Deadline 9 submissions to Planning Inspectorate, National Infrastructure Planning: Ref. TR010025

Prepared by Dr. G.M. Reeves for the **Stonehenge Alliance. Ref.2001870**

PART ONE: Summary response to Highways England's Deadlines 7 and 8 submissions REP7-081 and REP8-013 on matters relating to Flood risk, groundwater protection, geology and land contamination.

PART TWO: Response to Highways England's Deadline 8 Submission REP8-018: Written Summary of oral submissions put at Flood Risk, groundwater protection, geology and land contamination hearing on 29 August 2019, Appendix A - Highways England Comments on Dr GM Reeves Presentation.

Fig. 120. Simplified geological section of the Chalk and the phosphatic chalk deposits at Stonehenge showing the fault-controlled Stonehenge Bottom and the fault zone containing the thickest phosphatic chalks identified in cored boreholes and on the natural gamma borehole logs.

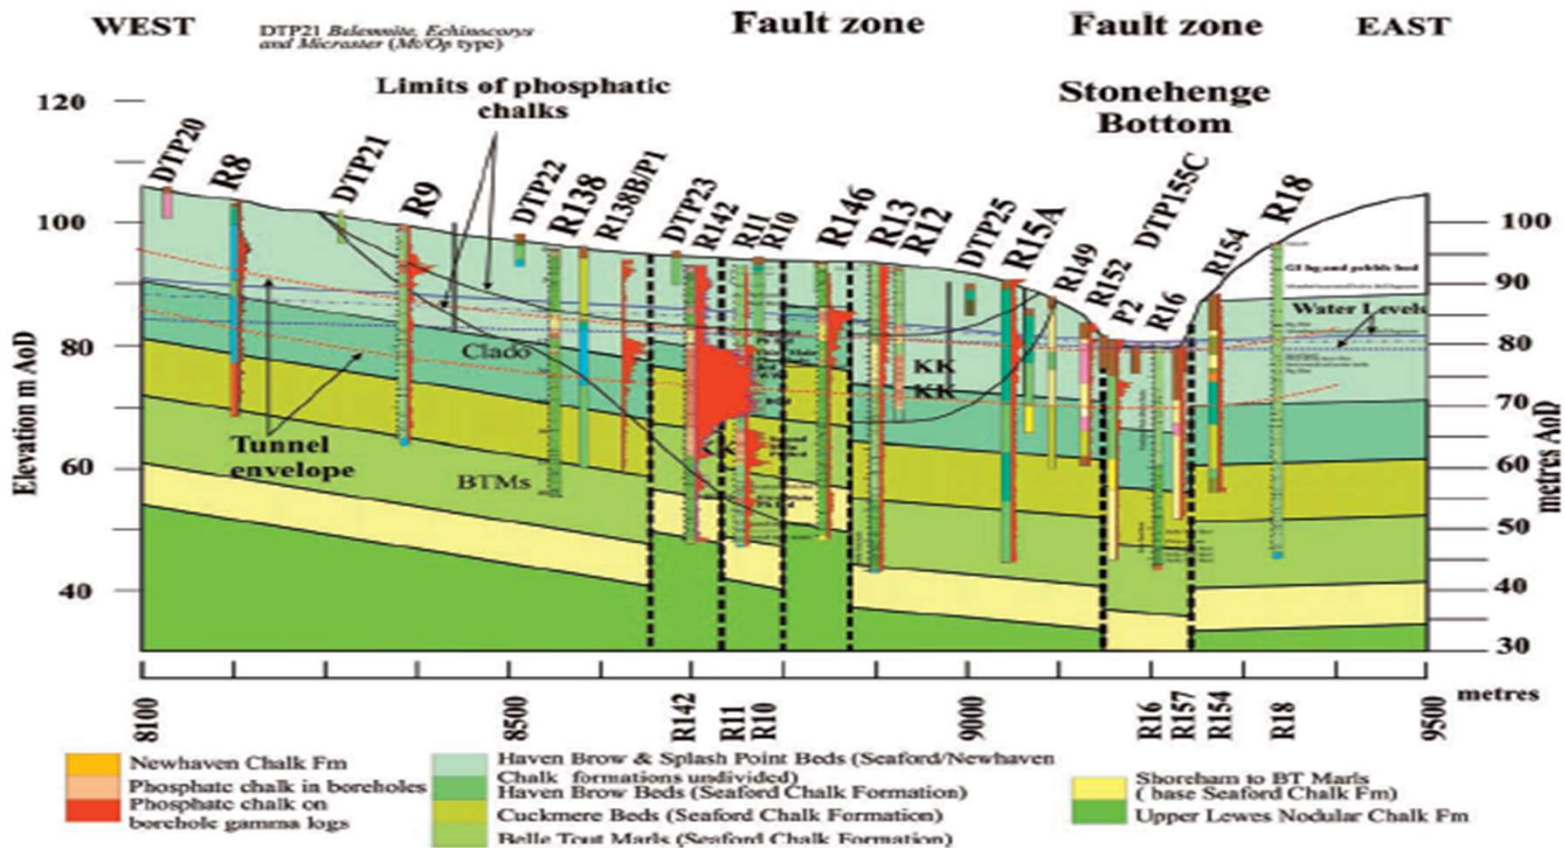
2.5.1. As mentioned in our ISH 10 summary of oral submissions, in examining the detail of groundwater and lithological data relating to the Whitway Rock horizon, it was noticed that Highways England had used a dated (2012) figure, attributed to Professor Rory Mortimore in his 2012 Glossop Lecture publication (for ease of reference, please see reproduction below). It remains uncertain if the AWM groundwater modellers have superimposed the profile of the proposed tunnel (as defined in the HEng A303 Amesbury to Berwick Down, Project Documents: 2.7 Engineering Section Drawings (Plan and Profiles documents) onto their Figure 2.

2.5.3. There is no obvious reason, nor any explanation why the Mortimore 2012 version of the proposed A303 tunnel route section is used and represented in AWM Report No. TR010025 Document 8.23 – Implications of 2018 Ground Investigations to the Groundwater Risk Assessment (republished with tracked changes, dated 31.05.19) by Travis et al. Why was Mortimore’s 2012 figure used in preference to the presumably up-dated figure (16a) in Mortimore et al., 2017? (shown below for ease of reference)

Figure 2 Chalk Stratigraphy with Tunnel and Chalk Rock Elevations (adapted from Mortimore (2012))

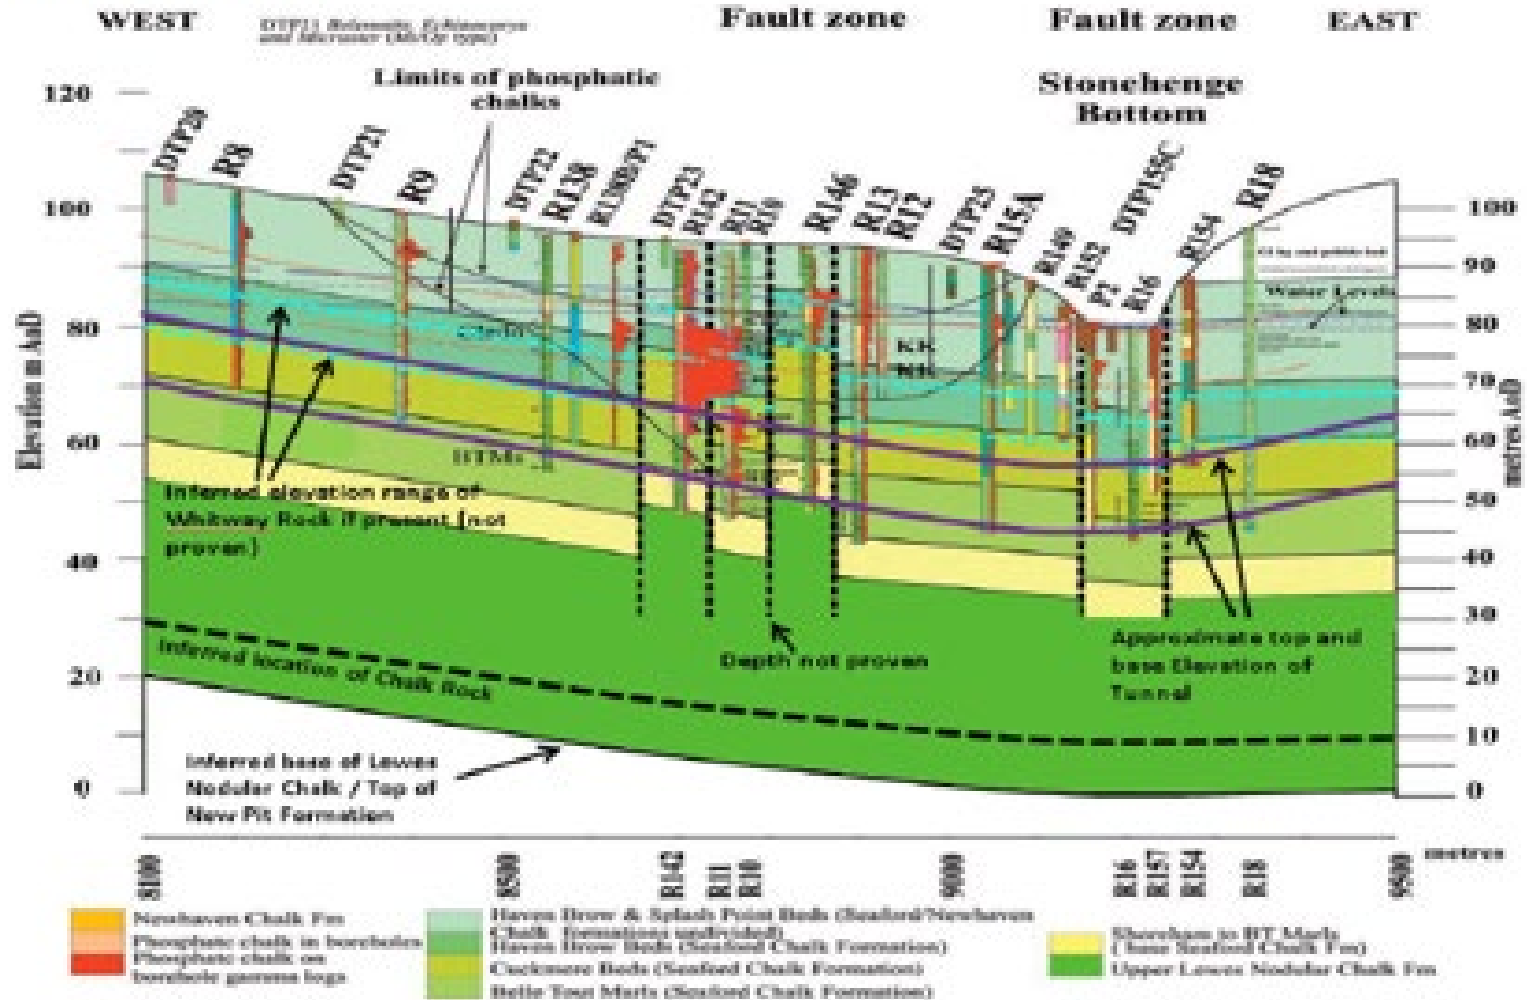
2.5.2. The groundwater levels and postulated zone range of the Whitway Rock horizon are also problematic (see figure below, as used in Stonehenge Alliance’s presentation to ISH 10).
